Our Ref: BN/98/21/DOC

Town & Country Planning Act 1990 (as amended)
Town and Country Planning (Development Management Procedure) (England) Order 2015
Approval of details reserved by condition imposed under BN/50/20/PL relating to conditions 5, 7, 8, 10, 11, 13, 17, 18 & 20.
Land North of 1 Northfields Cottages Fontwell Avenue Eastergate PO20 3RX

Arun District Council have decided to **APPROVE IN PART details reserved by condition**

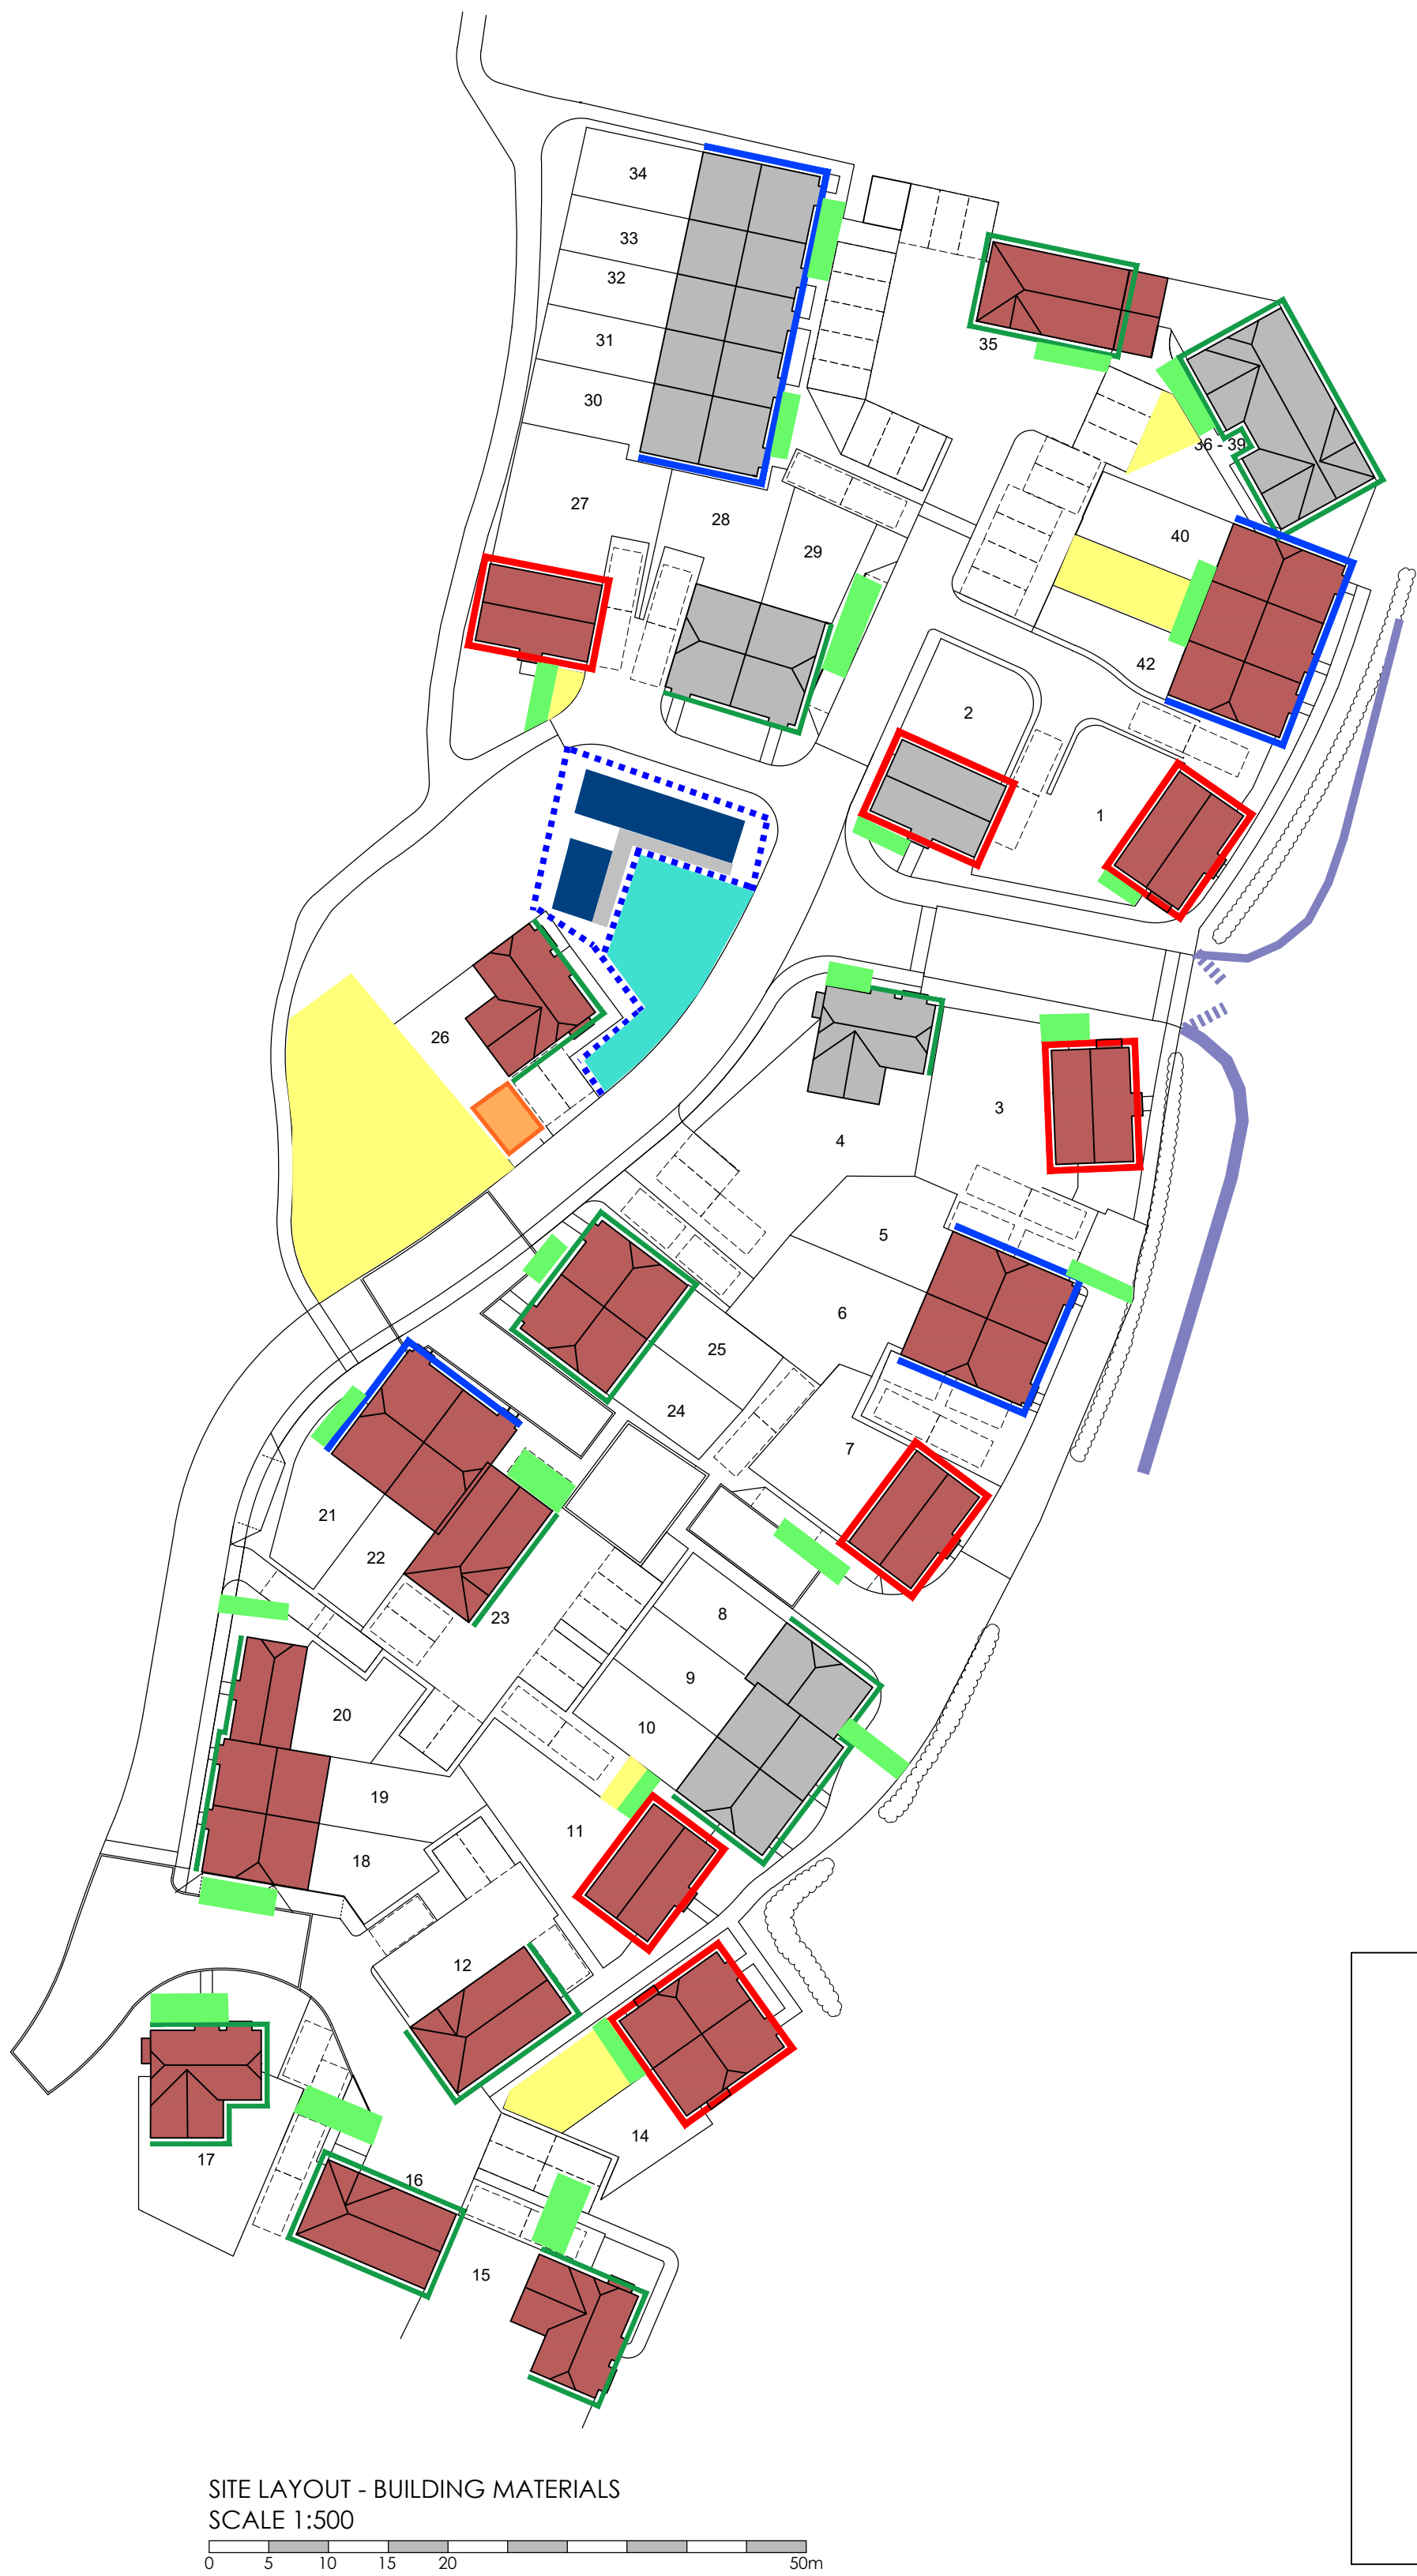
The condition requires a colour schedule of all materials and finishes to be used for external walls and roofs. You have provided a plan (20072-PL-205 "Site Layout Building Materials") which provides a material reference for each different plot and includes a key which specifies either Forterra Atherstone Red Multi Brick, Painted Brick, Weatherboard, Russell Grampions Red Tile & Russell Grampions Grey Slate.

The stated materials are acceptable (albeit on the assumption that the Russell roof materials are actually in the Grampian range as there is no evidence of a Grampions range on the Russell website) and are therefore discharged but it is unclear from the submission what type/colour weatherboard is being proposed or indeed what colour the painted bricks will be. These details will need to be

submitted separately to discharge the rest of the condition requirements.
